Hills Showground Station Precinct

Response to RFI by Department of
Planning, Industry and Environment

November 2020

Project	Hills Showground Station Precinct
Drawing Title	Building Heights Plan
Scale	1:2000 @A3

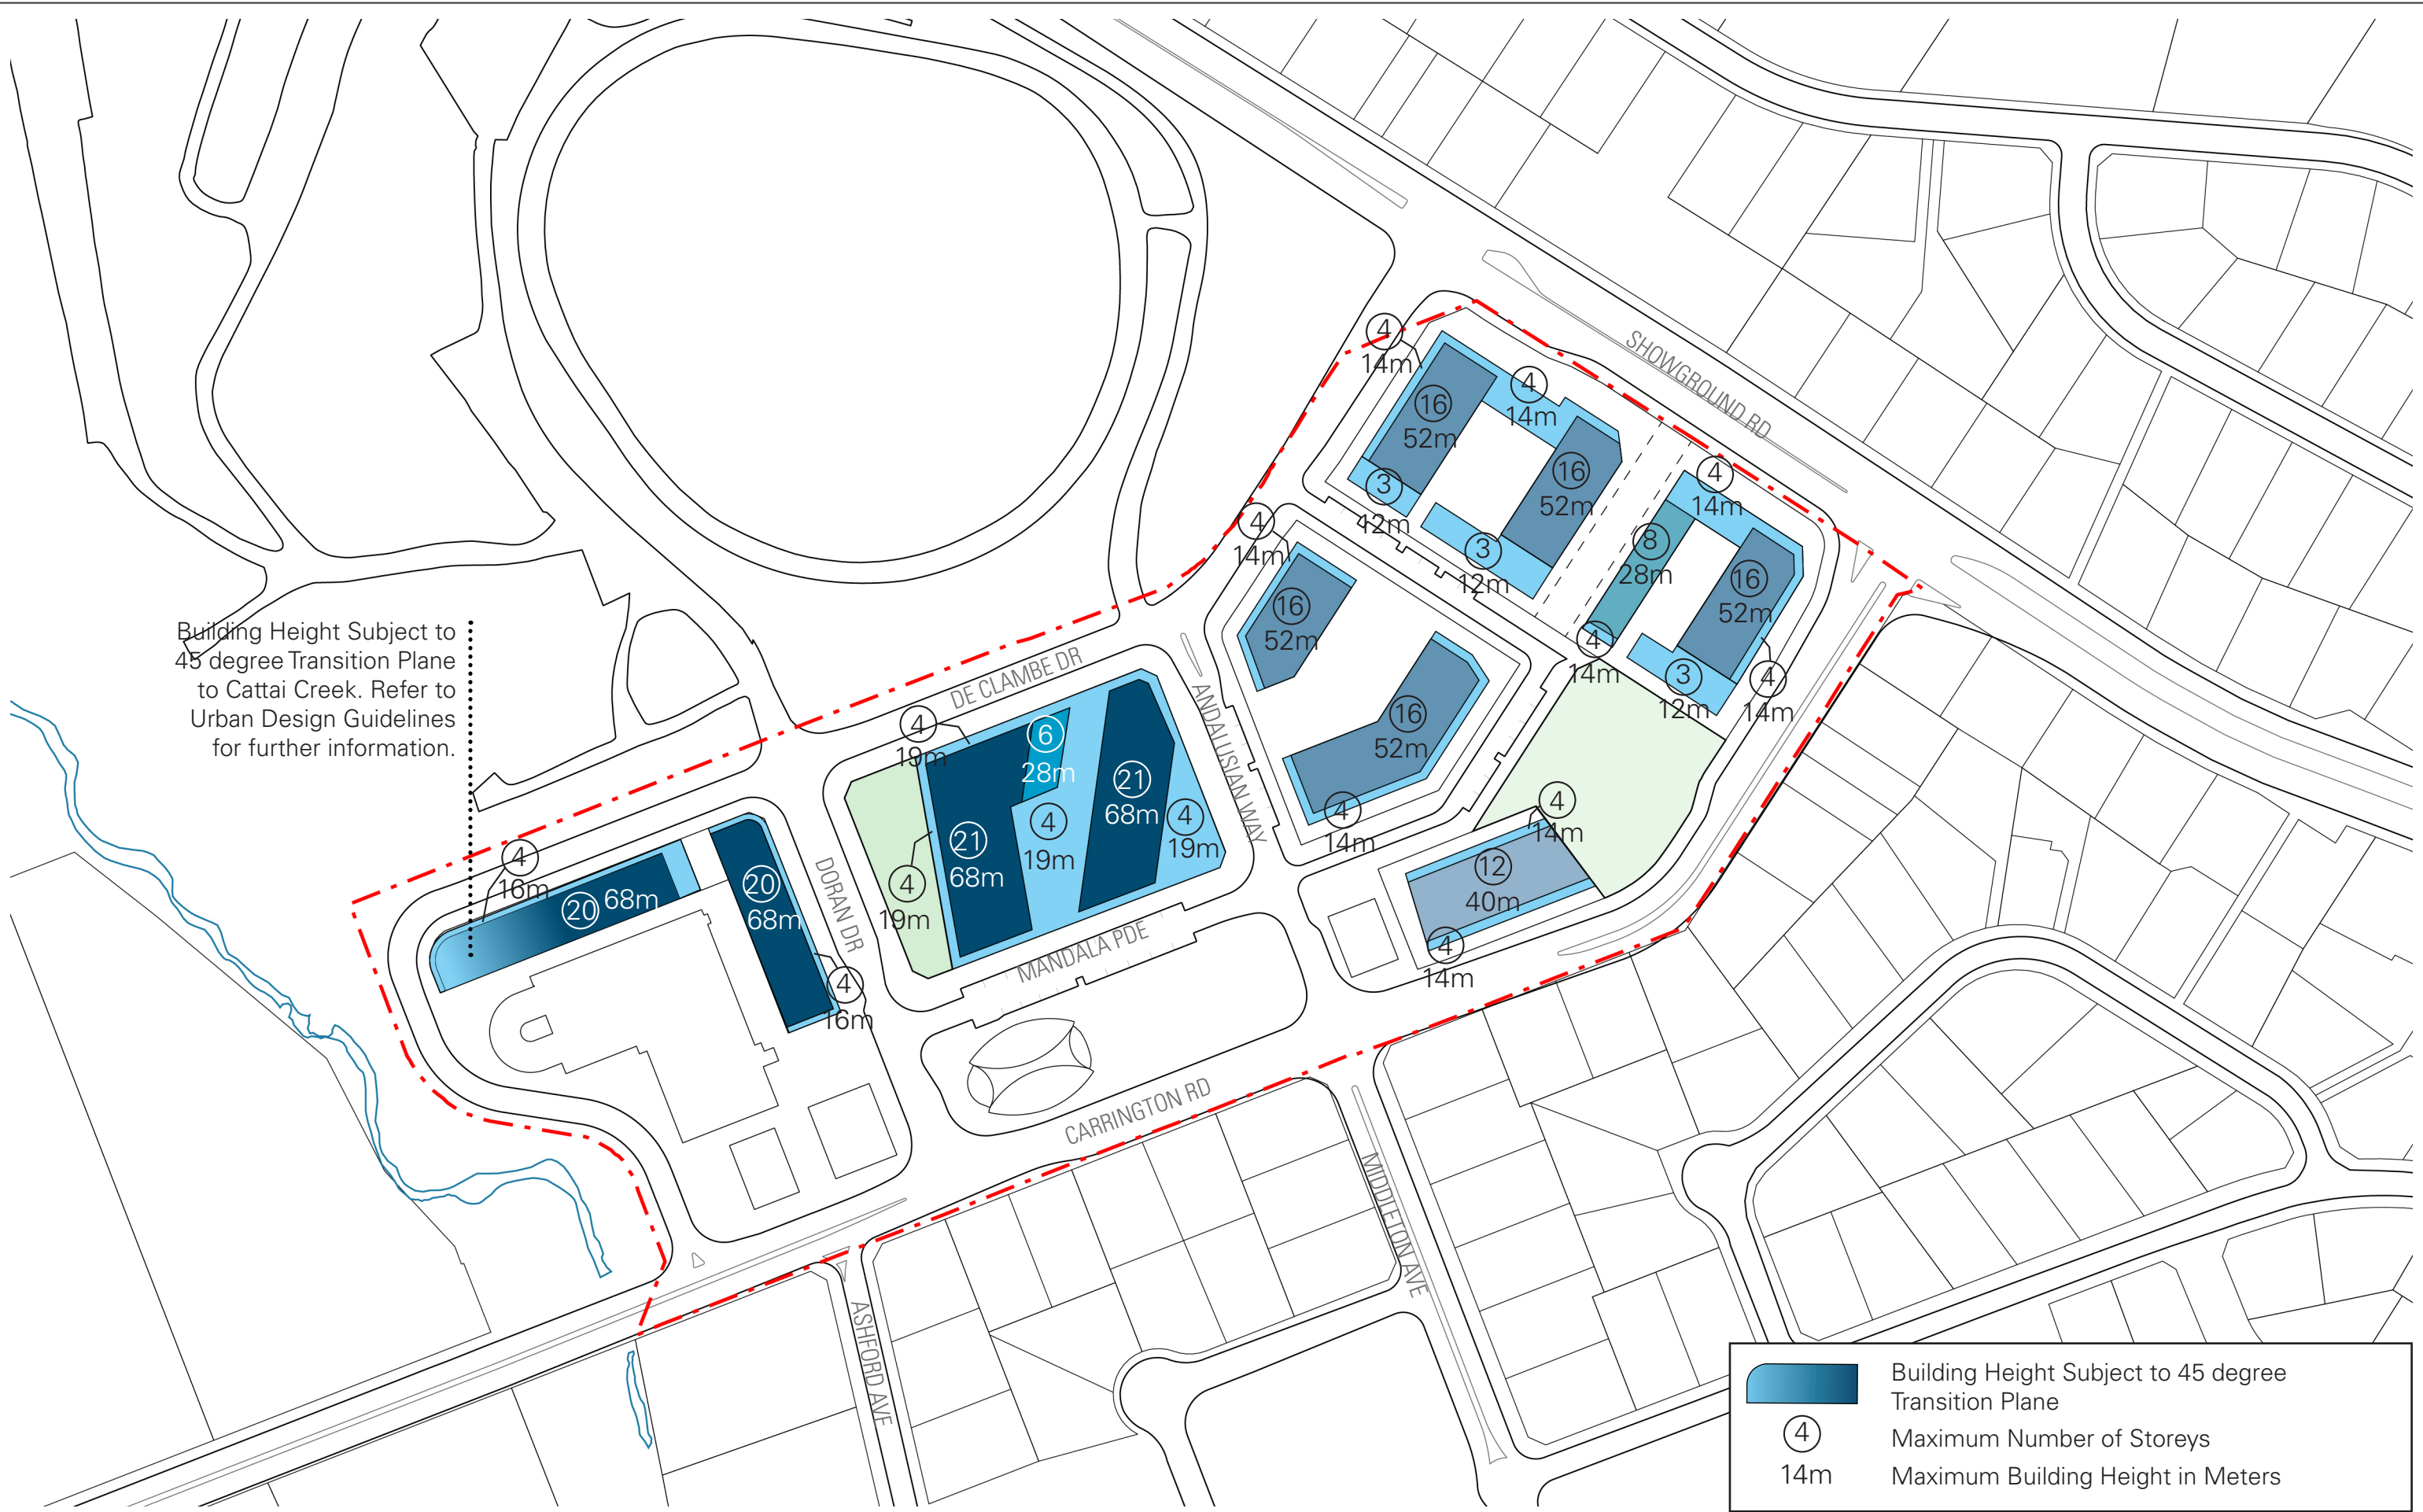
“Amend the Building Heights Plan to include both height in storeys and metres to be consistent with the proposed Design Guidelines.”

The drawings for approval - Building Heights Plan - has been amended to include heights in storeys and metres

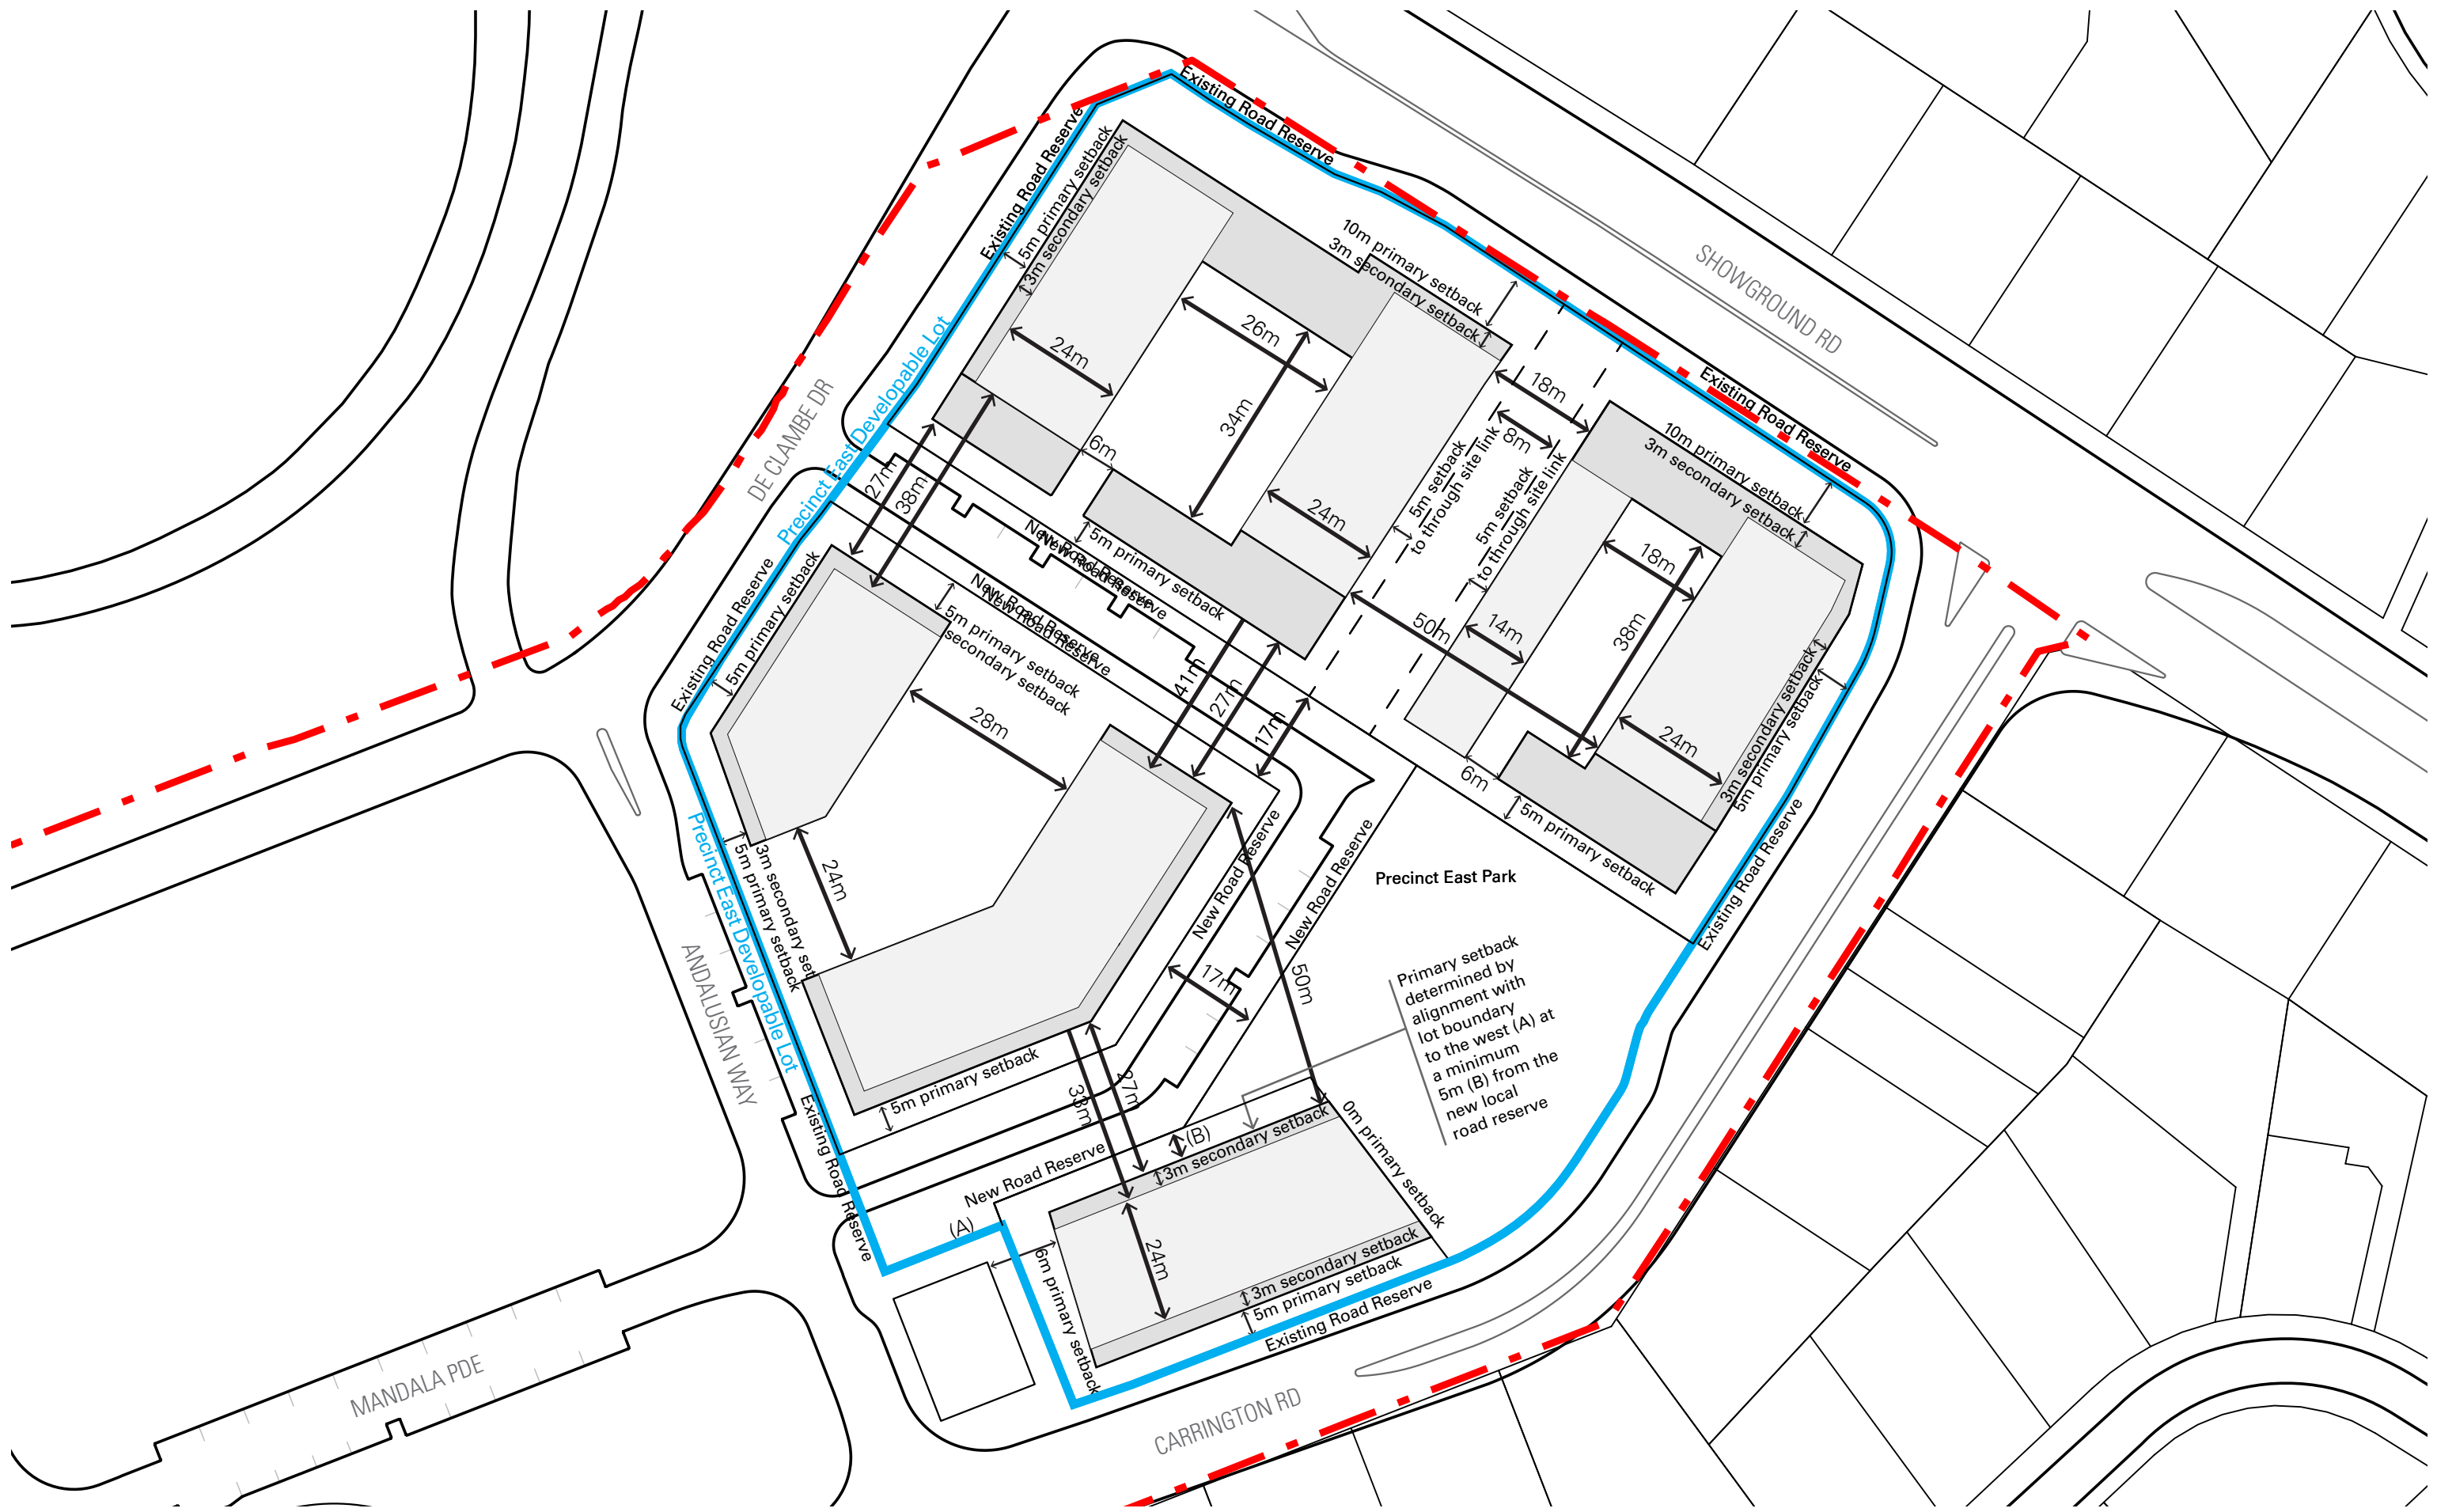
“Demonstrate the building separation distance between the proposed townhouses fronting Andalusian Way and Buildings P & R in Precinct East are sufficient to support good levels of residential amenity..”

In reviewing the Urban Design Guidelines for Precinct East, and in light of the RFI, we recommend that the 3m building separation between the townhouse apartments addressing the new local street and the new local park and apartment buildings P and R be removed.

Instead we propose to increase the building separation from 3m to 6m between the townhouse apartments and Buildings Q and M.

This ensures that there is greater residential amenity for residents of the townhouse apartments, and overall residents will benefit from a wider access way to the communal open space and any dwellings that are accessed from the communal open space.

Project	Hills Showground Station Precinct
Drawing Title	Long Section through Doran Drive Precinct and Precinct West
Scale	0 25 75m

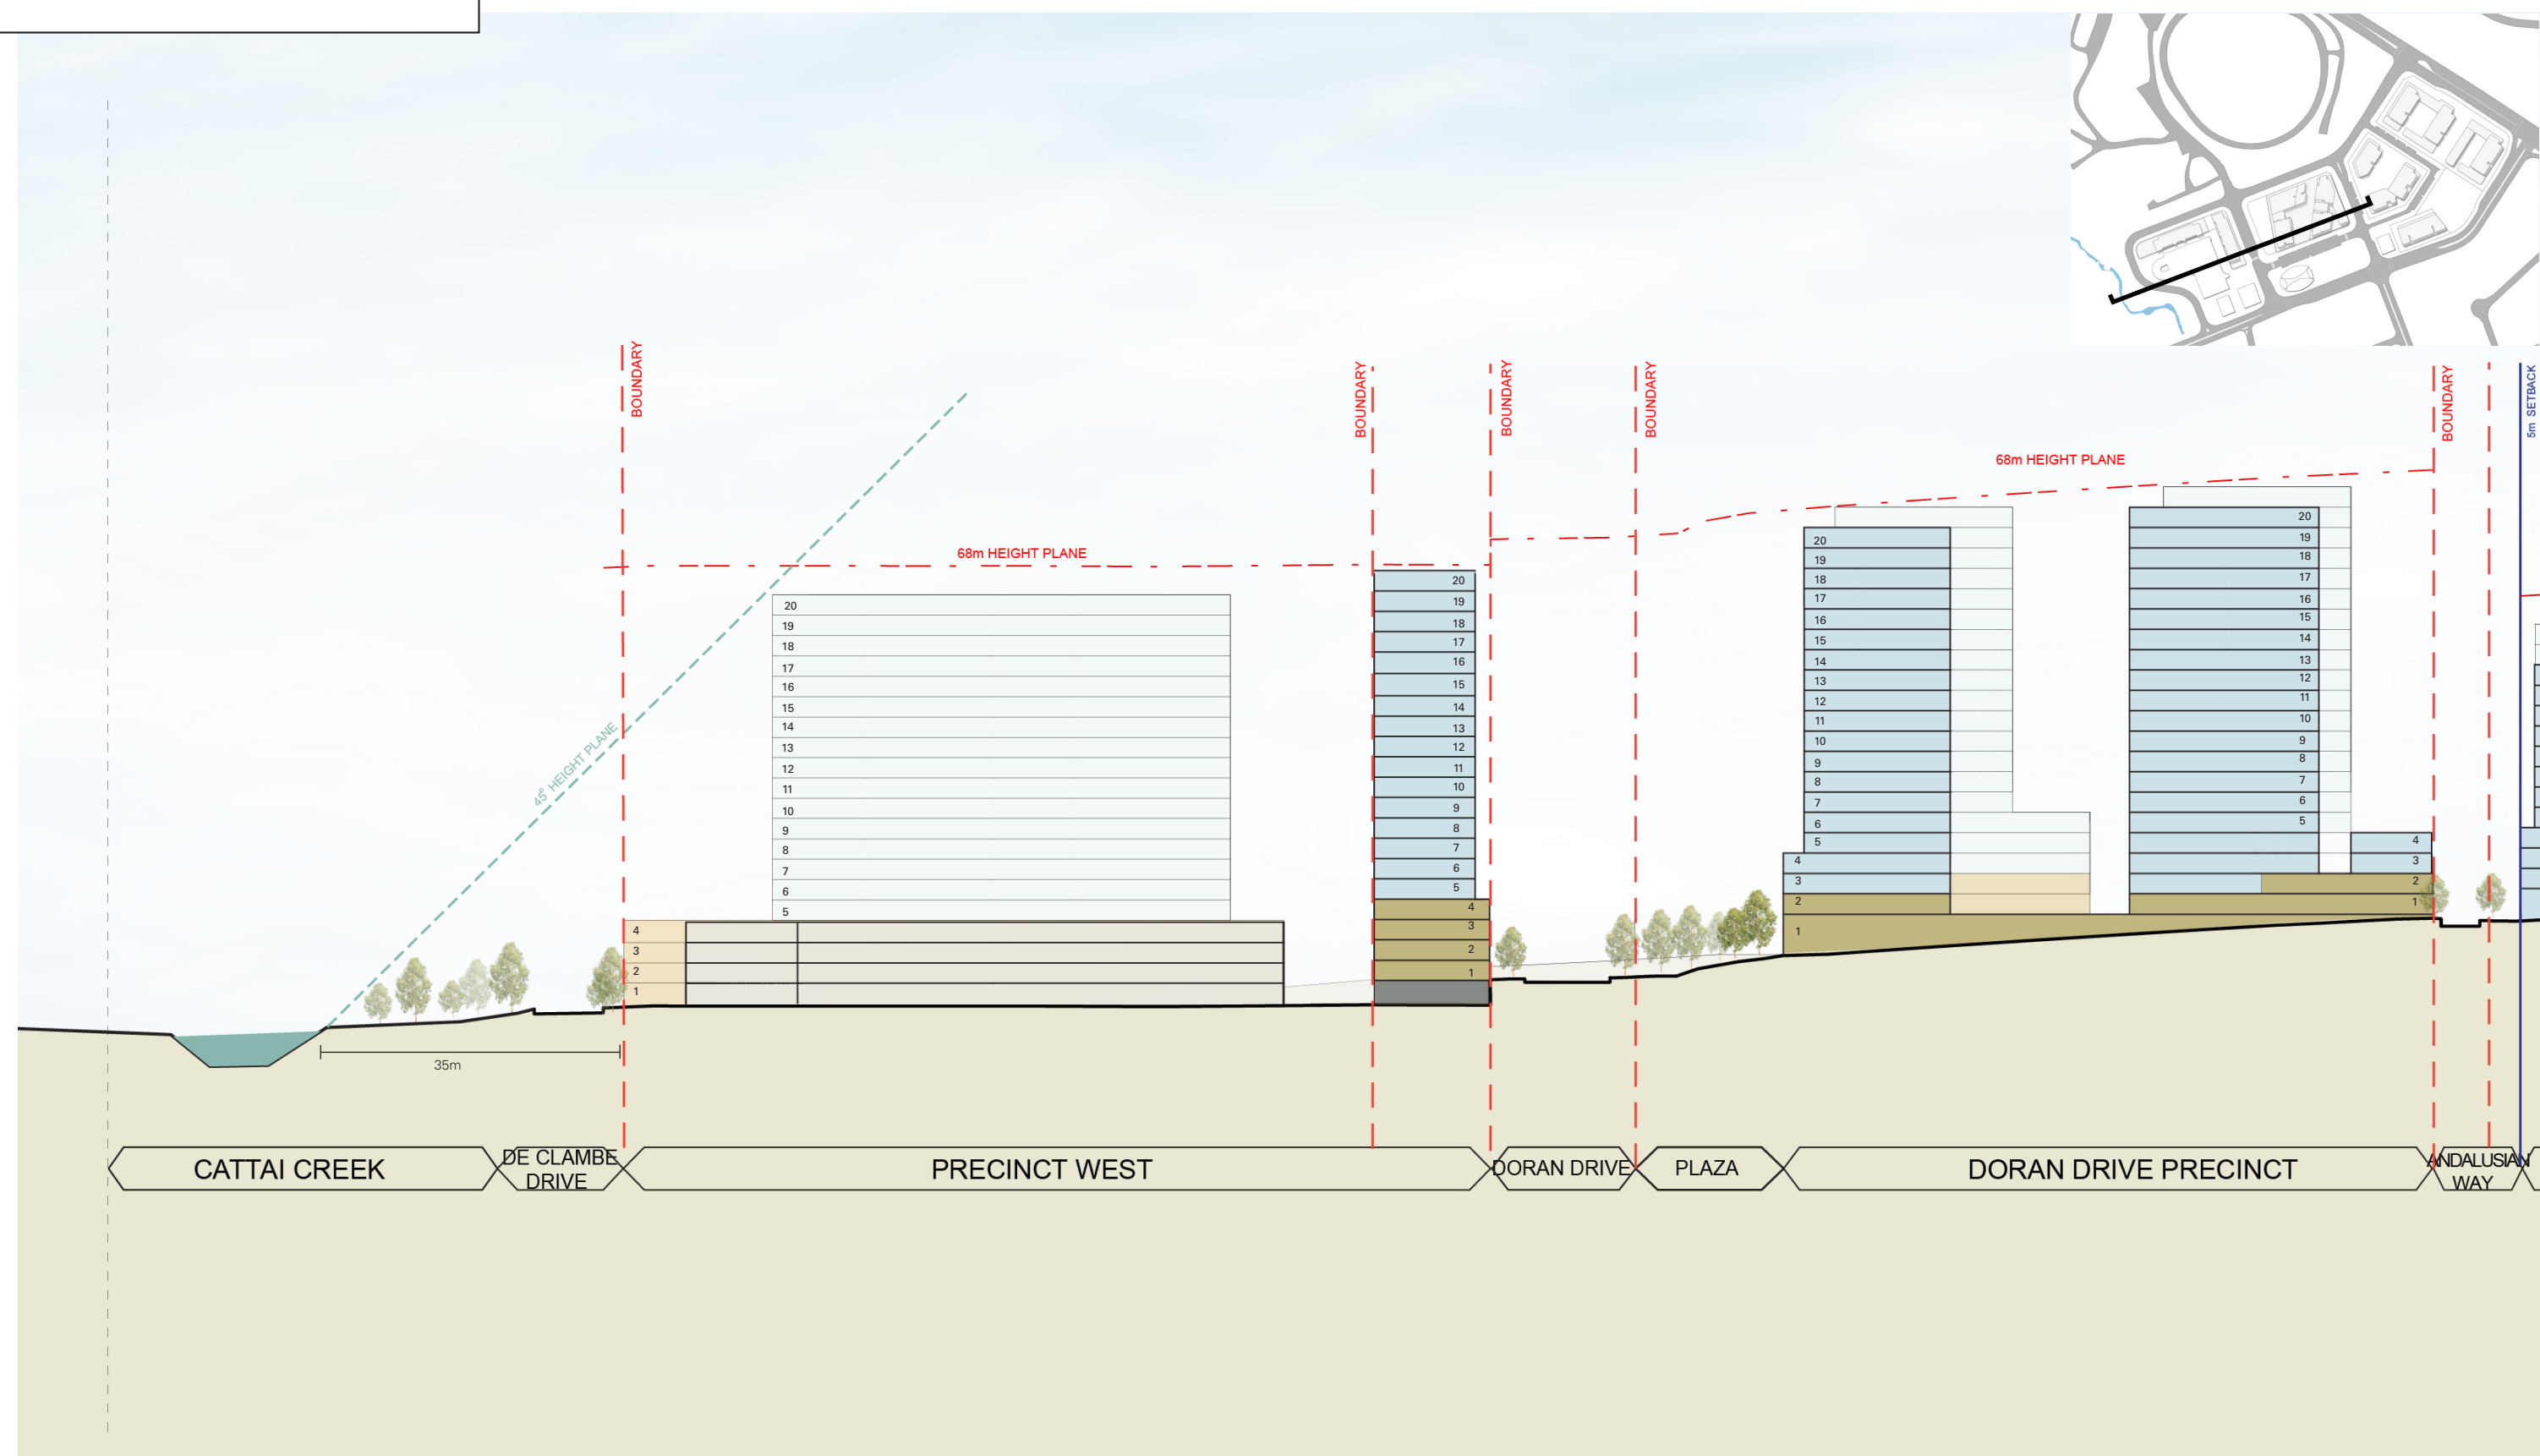
“Confirm where the top of the bank is measured from in Part 3.2.6 Control 1.”

A 35m metric has now replaced the “top of bank” from which the height plane is to be measured.

The 35m is to be measured to the east of the site boundary for Precinct West where it interfaces with De Clambe Drive and the Cattai Creek corridor.
